From: Amanda Scholes on behalf of Planning.Responses
Sent: 03 November 2017 08:35
To: Planning Scanning
Subject: FW: *EXTERNAL: LU/282/17/RES - Courtwick Lane - mixed use building
Attachments: Courtwick Lane Elevation sk01.pdf

I have discussed the proposed amendments to the elevations of the proposed mixed use building with my Team Leader, Claire Potts and it has been resolved that the building itself needs to be re-designed so that it accords with the wording on page 86 of the "Courtwick: A proposed urban extension to Littlehampton Design and Access Statement".

Drawing No: 16.041.005

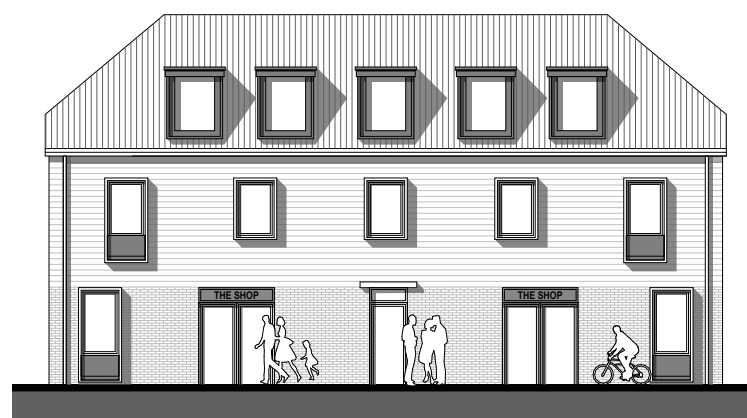
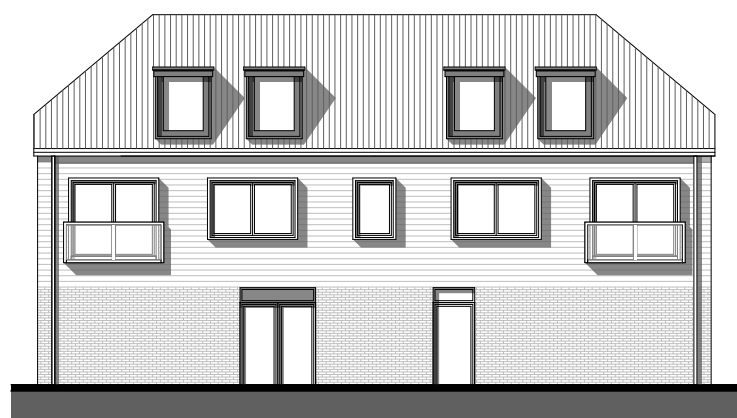
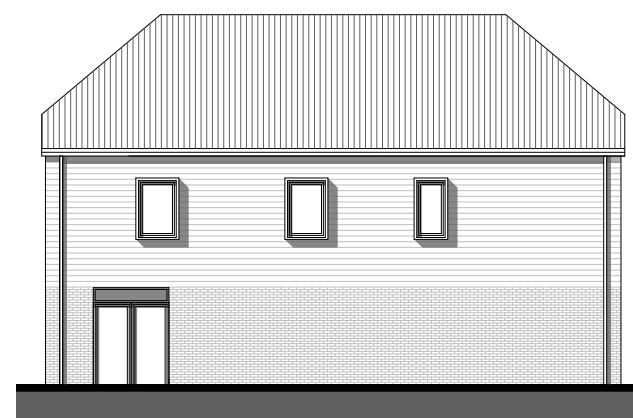
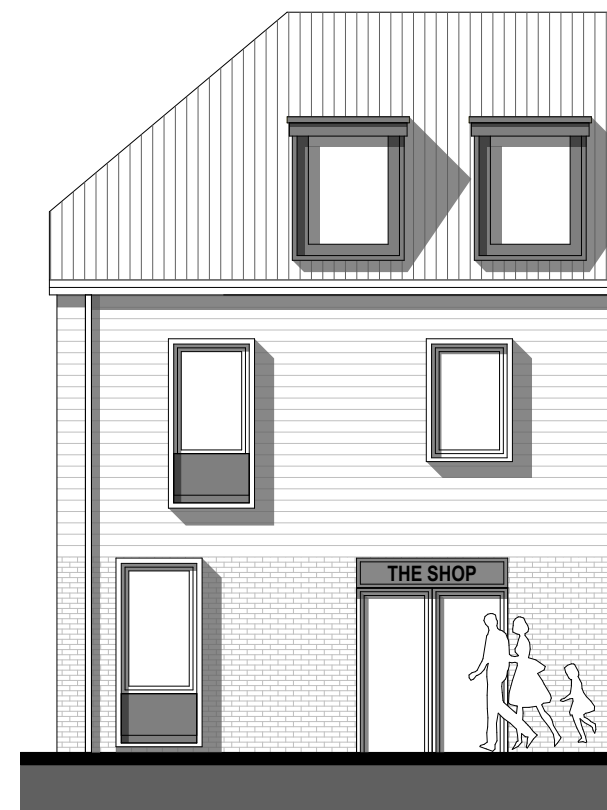
The wording on page 86 says: "At the northern edge of the (Village Green and Communal Centre) character is a mixed use building with apartments over a retail space. In architectural form and detailing, buildings in this character area must suit the scale and materials palette of the existing farm cottages and Court Wick Park. The mixed use building should reflect the stables part of the listed complex, with special wall finishes and a vertical element to the roof."

In terms of the vertical section within the roof, we do not wish to propose this element for a couple of reasons;

- with apartments over, this becomes quite a key maintenance issue for any prospective occupier of the apartments;
- the DAS does also include (page 75) building parameters for the mixed use building (including a ridge height max of 12.1m) – we are at 10.4m, so we are limited to what can practically be achieved in the space available;
- the drawings throughout the DAS could be best described as 'aspirational' and whilst they emulate elements of the stable buildings, the two buildings are never seen in the same context and are over 220m apart. With the stables obscured from view by trees, I'm not convinced that something that's similar to that hand sketched in the DAS would relate particularly well to the new dwellings it would sit alongside.

In terms of the amends made – we've focused on altering the ground floor front elevation to reduce the expanse of brick. This has been done by adding extra fenestration and introducing a soldier brick course above the windows and providing a more detailed front entry porch to the apartments. The door and window heights have been increased marginally which has allowed the extent of black cladding to be reduced slightly, which is something we felt gave a better sense of proportion to the appearance of the building.
